Title: **STAGE 2 ROAD SAFETY AUDIT**  
**For;**  
**Main Street Ardee**

Client: **Louth County Council**

Report reference: **2067R02 Rev 2**

VERSION: **March 2025 Addendum.**

job number:	drawing number:	revision:
HDC1256	1006 (K)	06

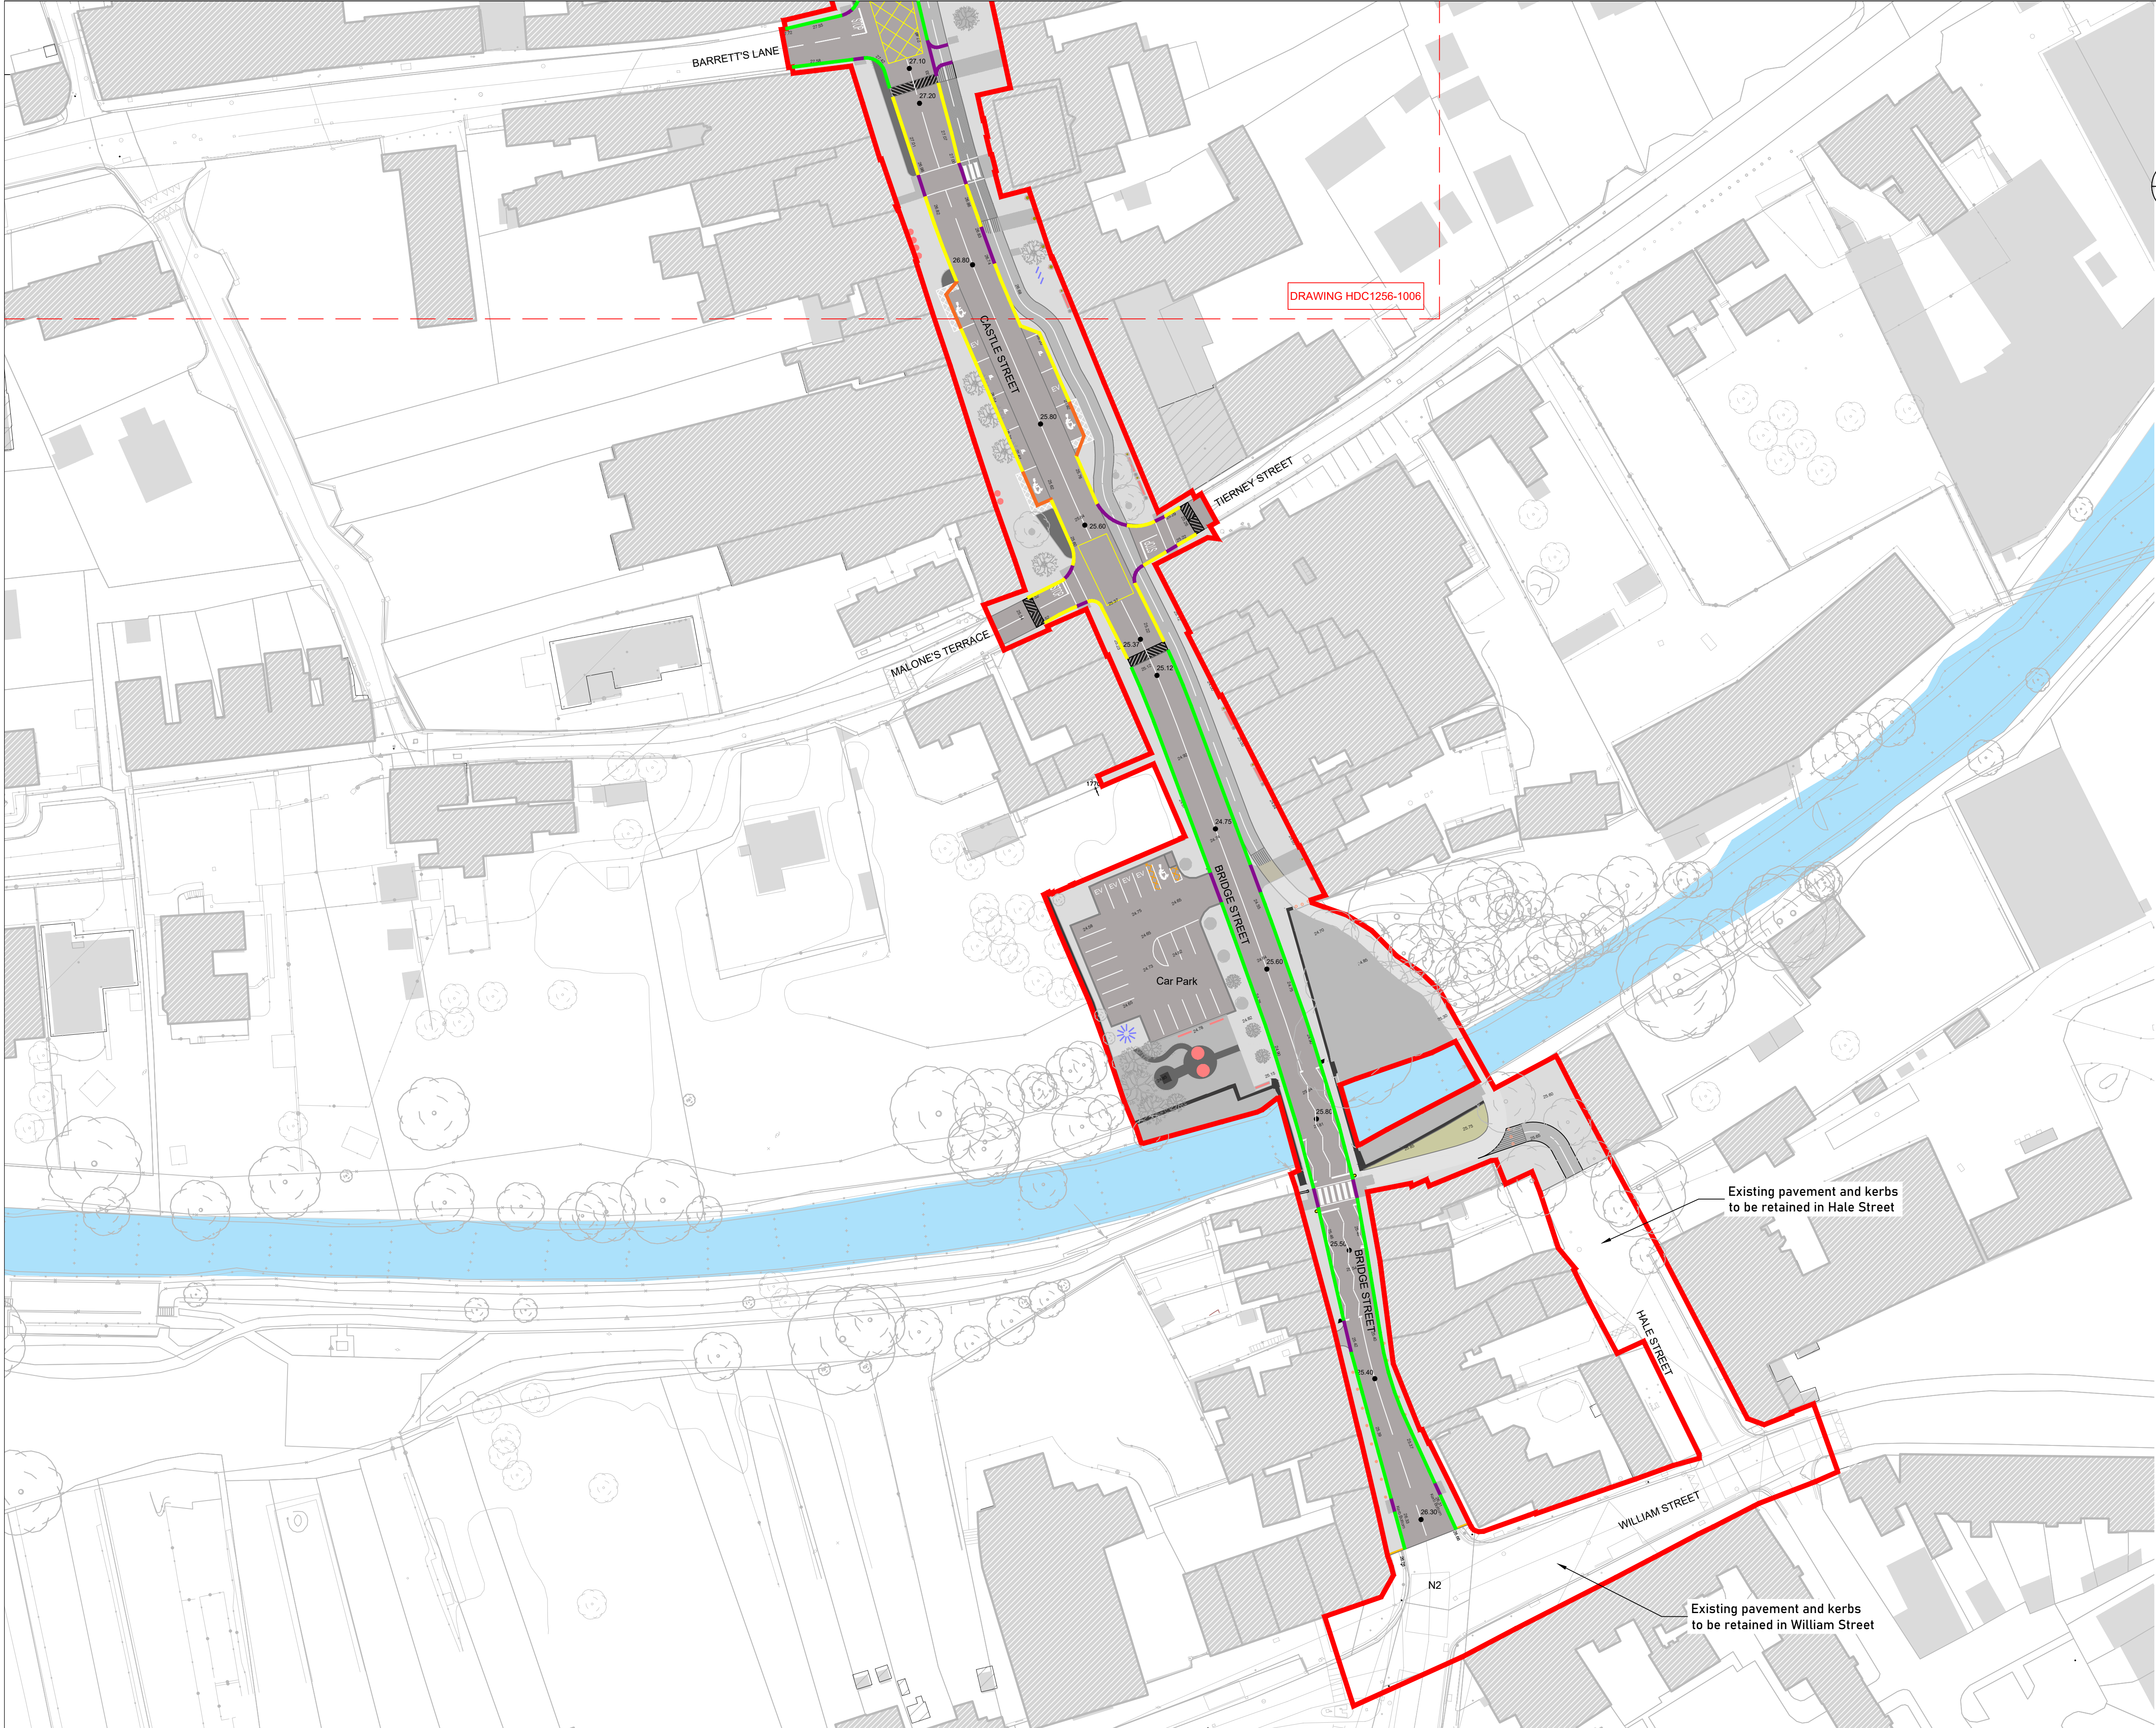
Drawing HDC1256 106 Rev 06, Toucan crossing south of Ash Walk.

The northbound cycle track commences within the L-shaped tactile paving. This area should be shared use and access to the push buttons should be available. The Zebra type road markings should not be provided at toucan crossings as priority may be confusing. A lack of clarity could lead to collisions between vulnerable road users and passing traffic.

Drawing HDC1256 106 Rev 06, Ash Walk, Shared Street.

Ash Walk is shown to be a 'Shared Street' It is unclear what distinguishing features or what signage will be provided to indicate this to users, especially drivers, as they enter this area. It appears that the footpaths are to be retained beyond the initial section from the N2 which does not signify a shared street but segregated facilities for pedestrians. A lack of clarity can lead to drivers presuming priority resulting in collisions.

Drawing HDC1256 106 Rev 06, Ash Walk.

Ash Walk is shown to tie-into a Part 8 scheme at the western end. Ash Walk is shown as a 'Shared Street'. It is unclear if the Part 8 scheme is to be a shared street and if its nature and use will therefore be consistent. A change of street type could increase the risk of collisions with vulnerable road users.

Drawing HDC1256 106 Rev 06, Ash Walk.

Ash Walk is relatively long and straight and one-way. This could lead to high vehicle speeds. High speeds leads to high injury severity if a vulnerable road users is struck by an errant vehicle.

Drawing HDC1256 106 Rev 06, Ash Walk, tie in with link road to the N52.

The link road to the N52 from Ash Walk is not shown to be a shared street. A change of street type could increase the risk of collisions with vulnerable road users.

Drawing HDC1256 106 Rev 06, benches adjacent to the cycle lane.

It is proposed to provide benches adjacent to the cycle track. If they are located too close to the cycle track they may be hazards for cyclists who may get their handlebars caught leading to loss of control and falls.

It is recommended that a standard layout toucan crossing be provided.

It is recommended suitable details be provided to denote a 'shared street' at its transition from the N2.

It is recommended that consistency in street type be provided.

It is recommended that traffic calming be provided along Ash Walk. (It is unclear if an existing raised table is to be retained)

It is recommended that that consistency in street type be provided or that a suitable transition be provided.

It is recommended adequate offset be provided at the edges of the cycle track without obstacles.

job number:	drawing number:	revision:
HDC1256	1007 (K)	08

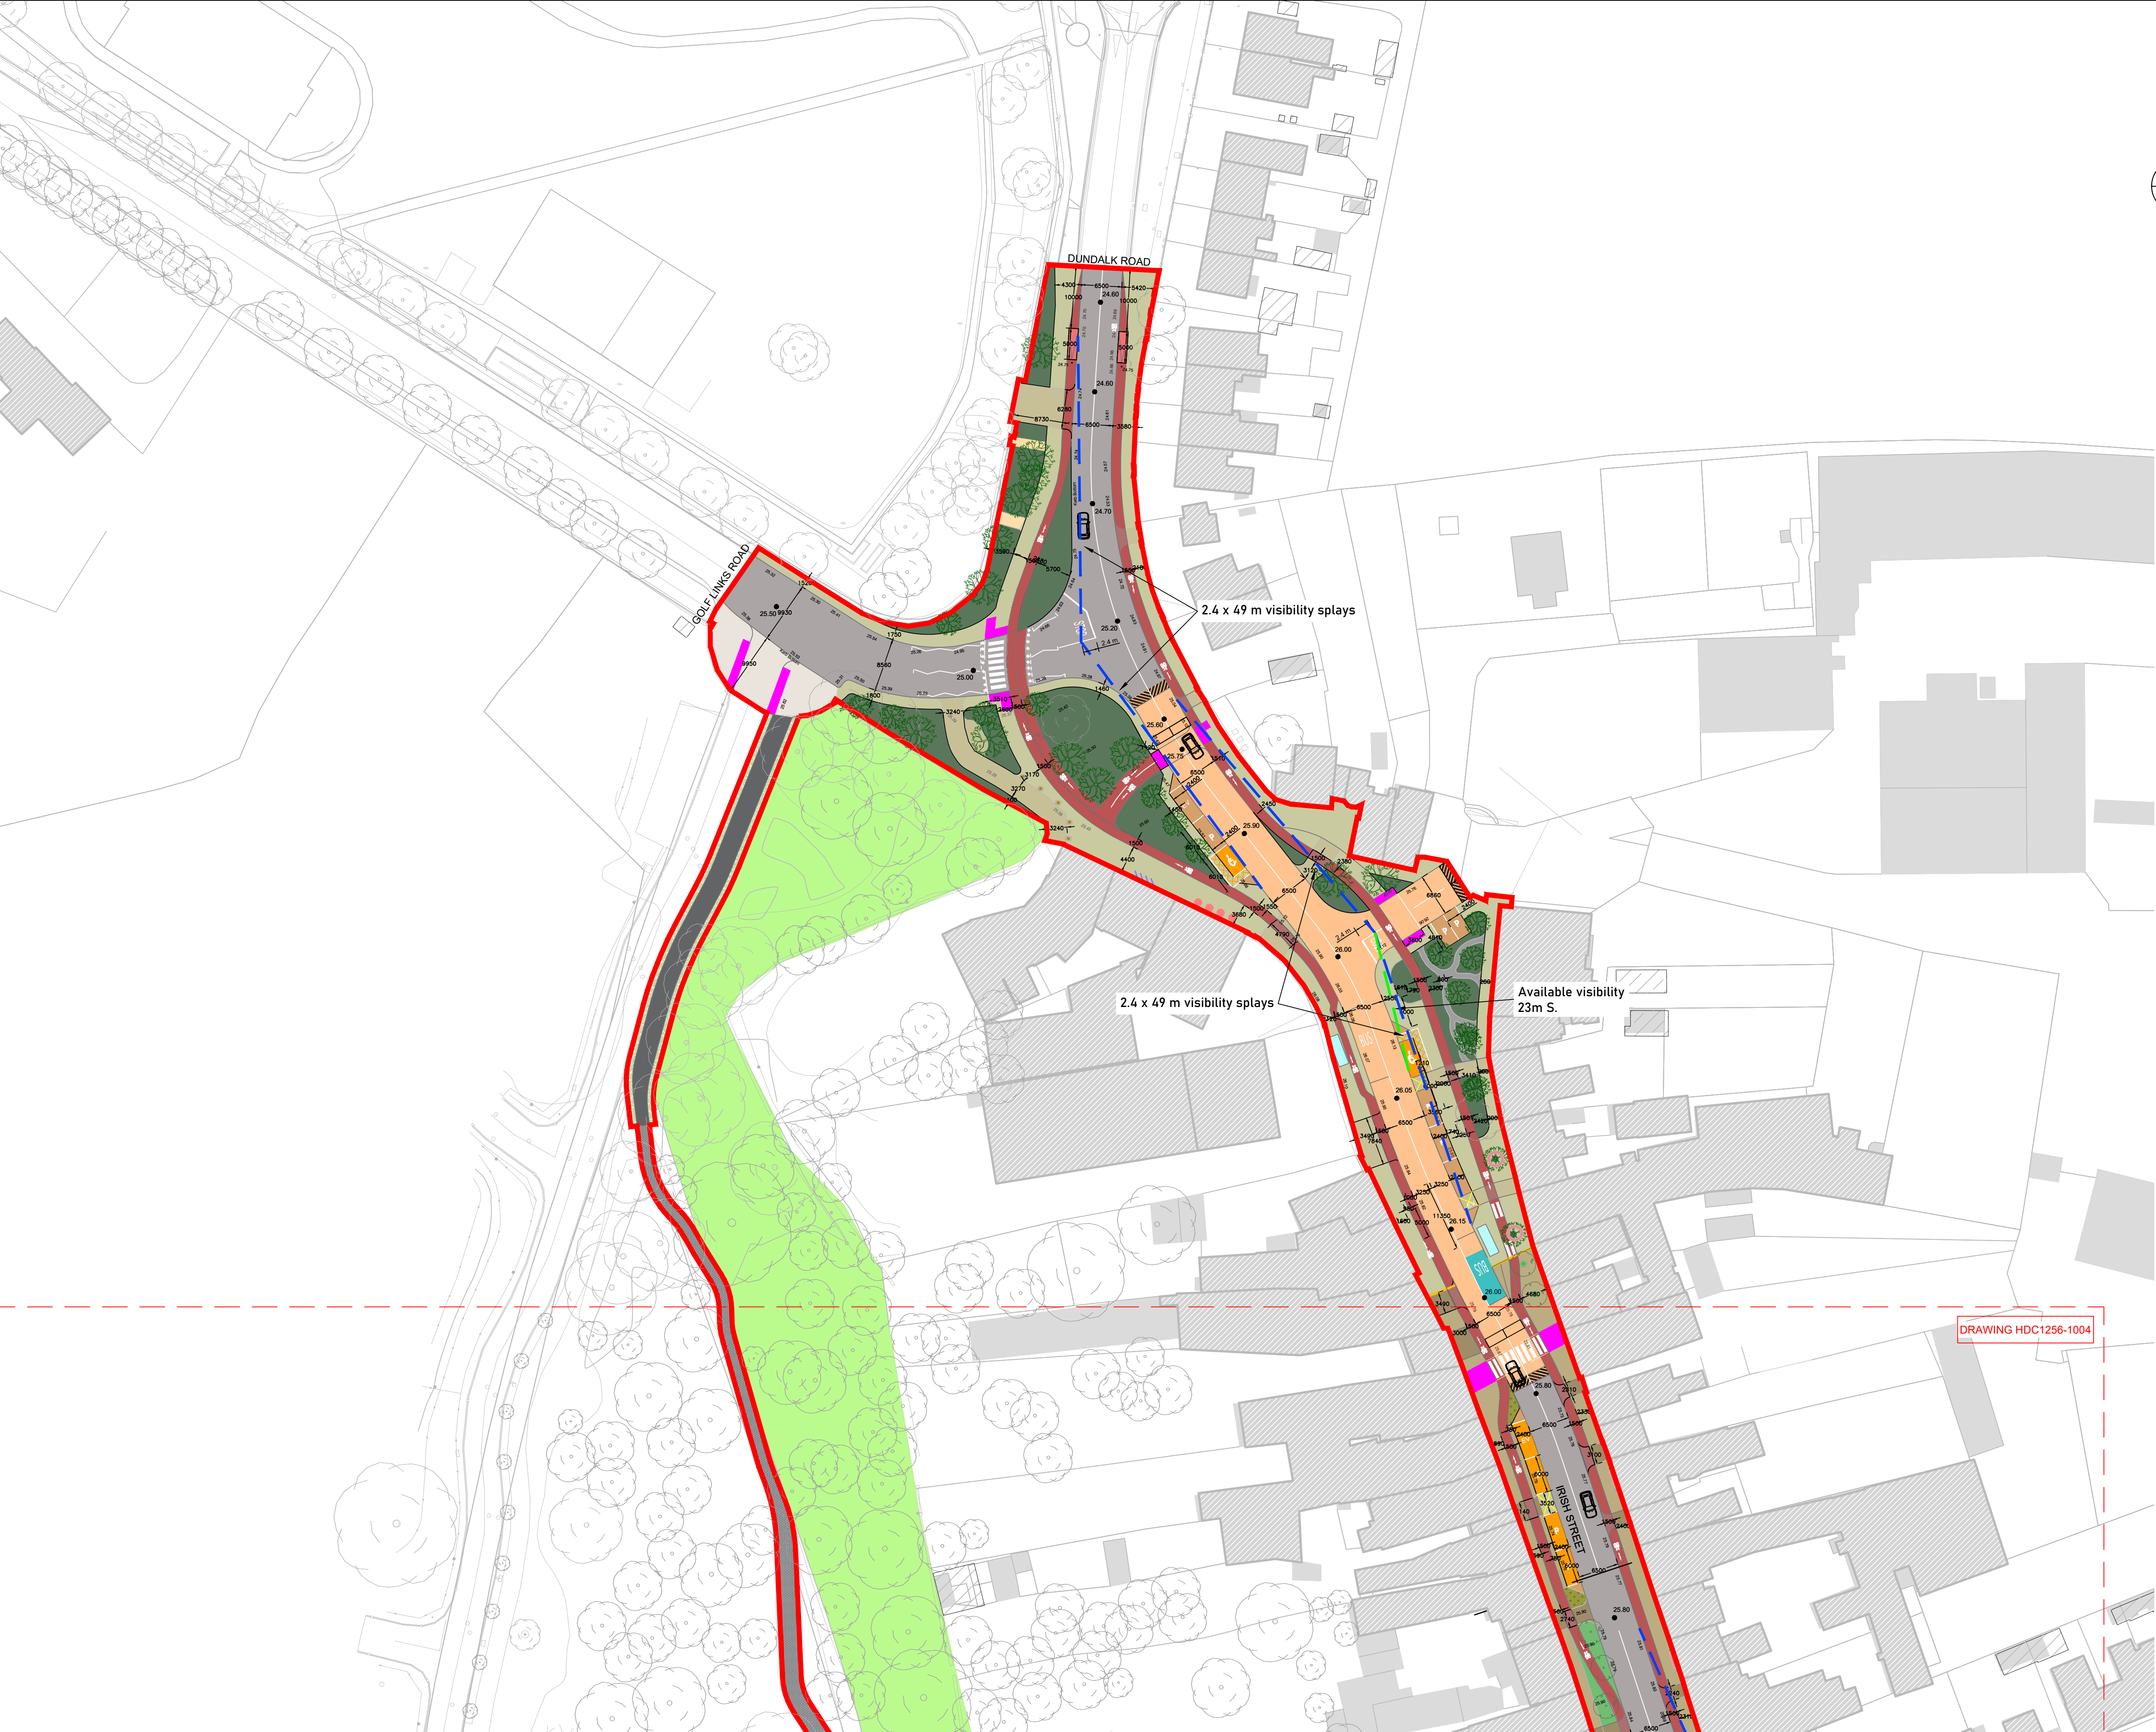
Drawing HDC1256 107 Rev 07, South of Dee River bridge.

There is no provision for northbound cyclists to exit the N2 and wait to cross the signalised crossing. Cyclists will therefore continue travelling northbound on the Main Street carriageway thereby increasing the risk of collisions with general traffic. A proposal to direct cyclists via Hale Street was suggested in the Feedback Form of the Stage 1&2 Road Safety Audit. That proposal does not appear to be included in this design update.

Drawing HDC1256 107 Rev 07, Interface of Shared use and cycle only facilities.

A lack of guidance at the interface of shared use and cycle only facilities could lead to blind or partially sighted pedestrians entering a cyclists only area which would increase the likelihood of a collision with cyclists.

Drawing HDC1256 107 Rev 07, South of Dee River bridge.

There is a pinch point in the carriageway south of the bridge. Wide vehicles currently operate an informal shuttle system to pass each other. This may not be possible with the introduction of the new crossing as vehicles may be stuck in position while queuing at the signals. This could lead to side-swipe collisions, damage to bollards and mounting of the footpath. It is noted from the site visit that queuing on the N2 is common for long periods of each day. (It was observed during the most recent site visit that flexible bollards in the footpath at this location have been struck many times and have collapsed)

Drawing HDC1256 107 Rev 07, Pedestrian /cyclists bridge over the River Dee.

The two-way cycle track leads to a shared use area on approach to the bridge. Pedestrians have no area to join the shared use area. This could result in pedestrians crossing the road bridge which has a very narrow footpath and pedestrians would be subject to wind forces from heavy goods vehicles possibly leading to loss of balance.

Drawing HDC1256 107 Rev 07, Car park north of Dee River crossing.

Some proposed car parking spaces appear to be difficult to enter and egress especially if the adjacent spaces are occupied. This could lead to material damage of vehicles or inaccessibility for some users with mobility impairment but not sufficient to be entitled to use the disabled spaces.

Drawing HDC1256 107 Rev 07, Cycle track adjacent to the carriageway.

Some portions of the two-way cycle track are adjacent to the N2 carriageway. The N2 (being a national primary route linking Dublin to Derry and connecting with the N52 (without tolls)) has a high percentage of heavy goods vehicles (HGVs) and the lack of a buffer could lead to less confident cyclists wobbling,

Drawing HDC1256 107 Rev 07, Pedestrian Crossing at Ardee Castle.

The pedestrian crossing at Ardee castle has a two-way cycle track on the eastern side. A lack of warning could lead to blind or partially sighted pedestrians not realising they are sharing space with cyclists.

Drawing HDC1256 107 Rev 07, N52 Barret's Lane.

The N52 is a national secondary road which is proposed to bypass Ardee in the future as part of a separate scheme. There is however no guarantee that this scheme will progress and a high volume of HGVs will continue to use the N52 if this scheme progresses. Although the N52 junction is being built out from its current layout it is unclear if HGVs will be able undertake the turning manoeuvres from and to the N2 in both directions. A lack of space would lead to overrunning of the footpaths, cycle track or side swipe/head-on collisions with other vehicles.

It is recommended that a transition from on-road to off-road be provided for cyclists.

It is recommended that suitable tramline tactile paving be provided at the interfaces.

It is recommended that an analysis be carried out of the likelihood of queues at the pinch point and the possible need for a longer formal shuttle system.

It is recommended that an area be provided for pedestrians to access the pedestrian bridge.

It is recommended that adequate turning space be provided for all car parking spaces.

It is recommended that the 30km/hr speed limit be confirmed or that a buffer zone, bollards or a suitable kerb upstand be provided.

It is recommended that a well-defined shared area be provided with suitable ladder and tramline tactile paving at either side. This applies to other similar crossings throughout the scheme.

It is recommended that a swept path analysis be carried out for HGVs to ensure that turning manoeuvres can be undertaken. If this cannot be achieved a signalised junction may be required.
